# CITY OF ALBUQUERQUE

**Re: FedEx Ground ABQ Drainage Report and Grading Plan and Drainage Plan  
Engineer's Stamp Date 9-12-14 (K09D026A)**

DRAWN BY
DY
DATE
7-22-14
2013075-GRE
SHEET #
GR-1
JOB #
2013075

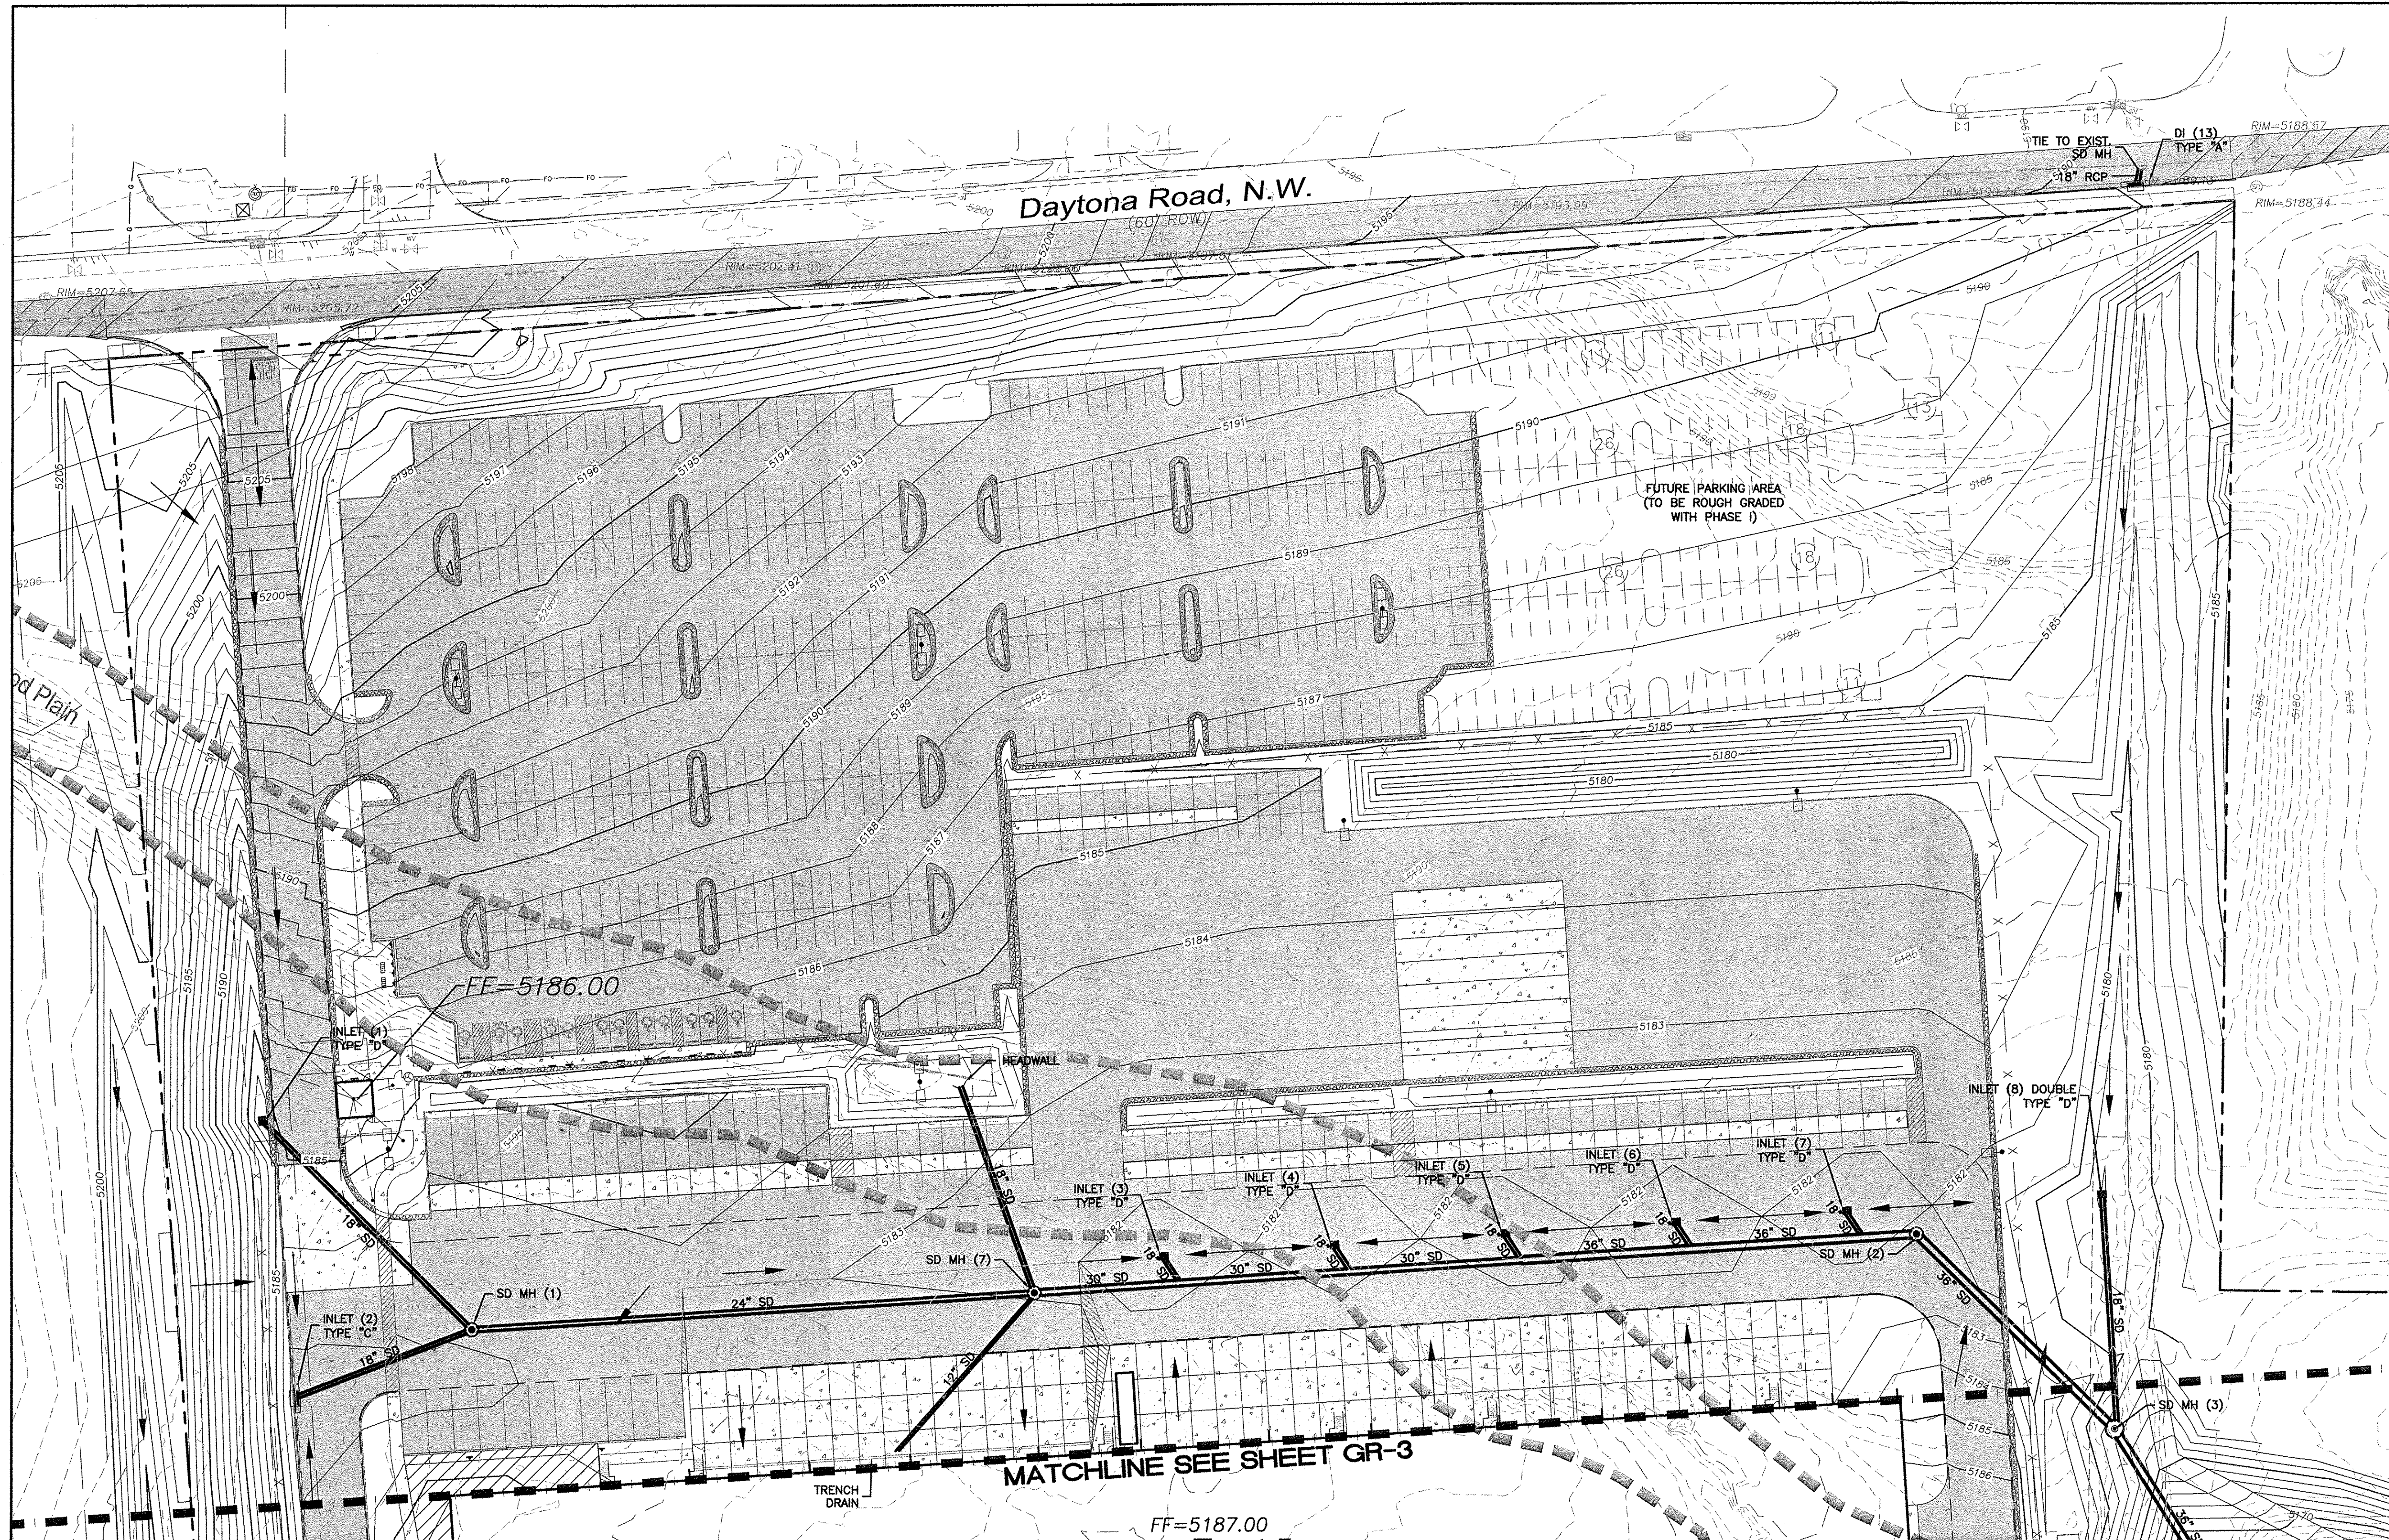
1. On sheet G-6, a desiltation pond is shown northwest of Daytona. Provide rip-rap on the upward slope from the bottom of the pond elevation to the top of pond. Include a top of pond elevation. Show existing contour elevations that the pond is tying into. What is the top of pond elevation? Provide a swale from the top of pond to the concrete pad for the 24 inch storm pipe. Ultimately, the 24 inch storm pipe will receive 48 cfs. The pipe is at a 20% slope. Reduce the slope and provide the HGL for the proposed 24 inch and 36 inch pipe in Daytona. Also provide the HGL for the storm drain in Los Volcanes. The ROW for Daytona begins to curve near the pond. Show the correct ROW.

3. For the pond north of Los Volcanes, provide enough distance for the slope so that it is actually 3:1 as called out on the plan.
4. Show the storm drainage on the master drainage plan so it easier to follow the report. Two pipe #20 references are shown. The one by the inlet should be #22 not #20.

VINCENT P. CARRICA P.E. #16212	ENGINEER'S SEAL	FEDEX GROUND ALBUQUERQUE, NM	DRAWN BY DY
	GRADING AND DRAINAGE PLAN	TERRA WEST, LLC 5571 MIDWAY PARK PLACE NE ALBUQUERQUE, NM 87109 (505) 858-3100 www.tierrowestllc.com	DATE 10-9-14
			2013075-GRE
			SHEET # GR-3

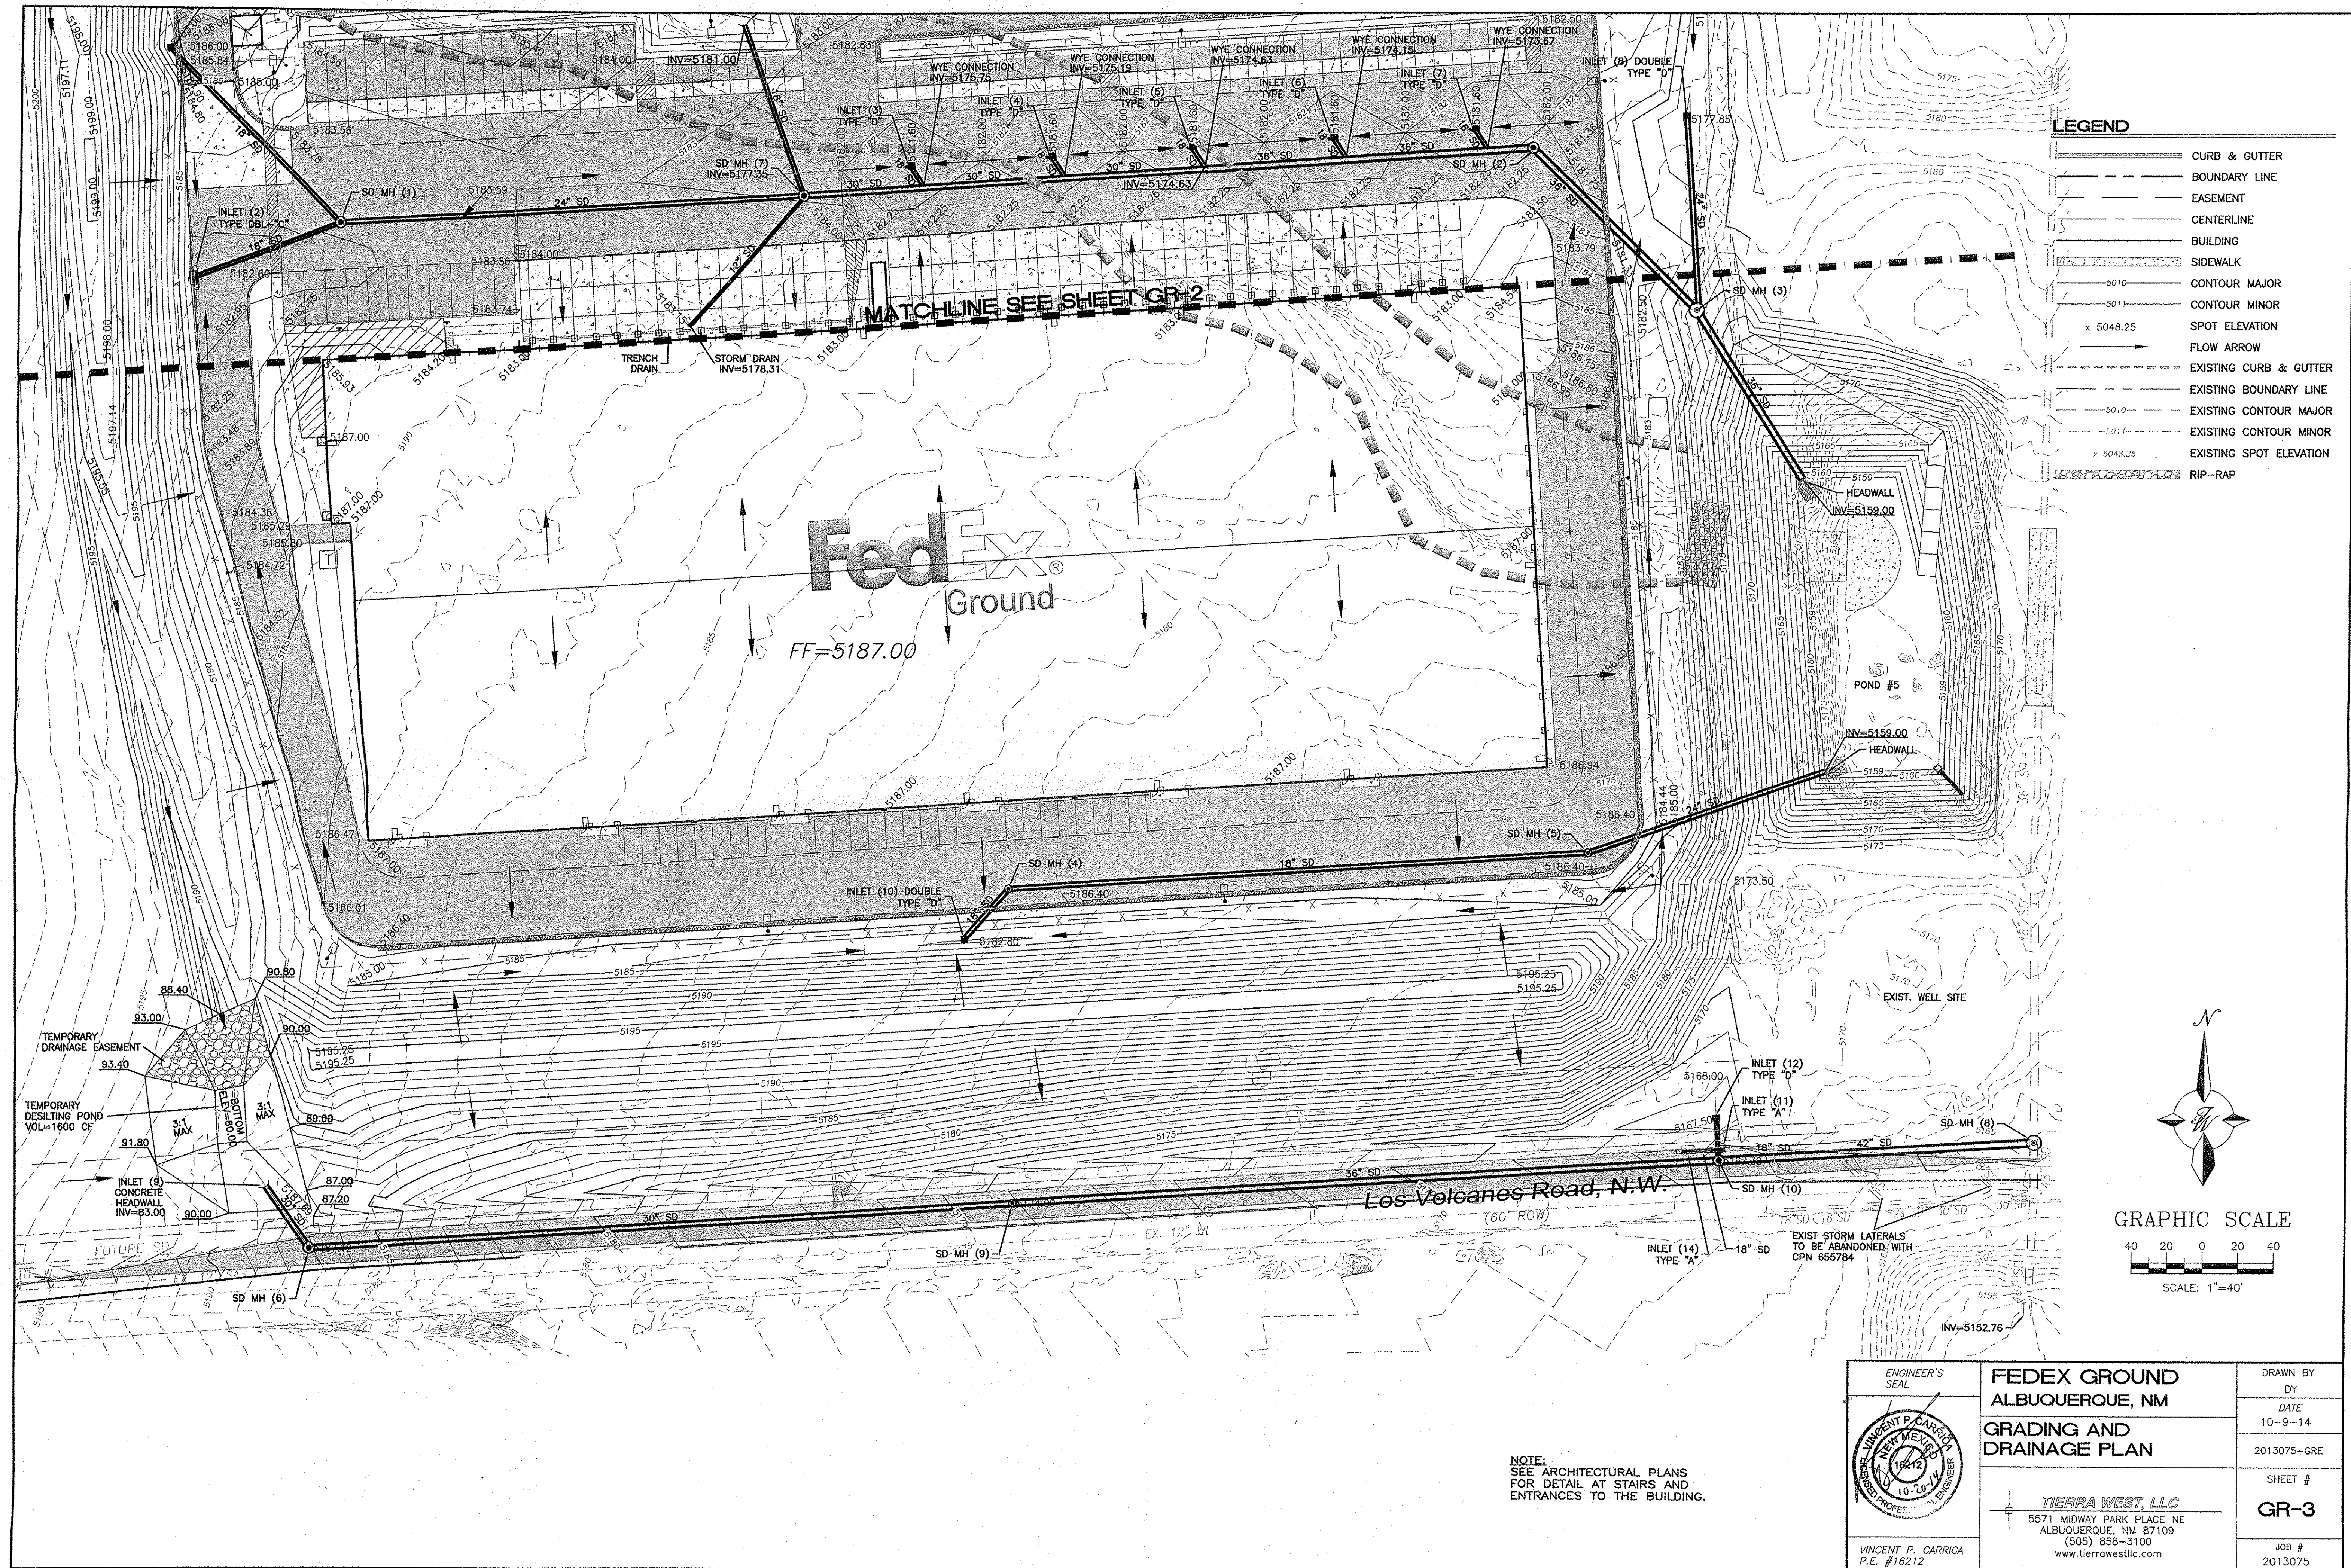
7. Provide a detail (width and size) for the rip-rap along the east and south sides of the parking lot.
8. Where the 18 inch storm drains connect to the storm pipe north of the building, what are the inverts?
9. Inlet (2) is supposed to be a double inlet per your letter. Call it out as such on the grading plans.
10. An easement for Floodway and Storm Drainage Works is on the east side of Tract 5-A of Avalon Subdivision Unit 5. The platting action through DRB should be complete prior to the Certificate of Occupancy for this site.
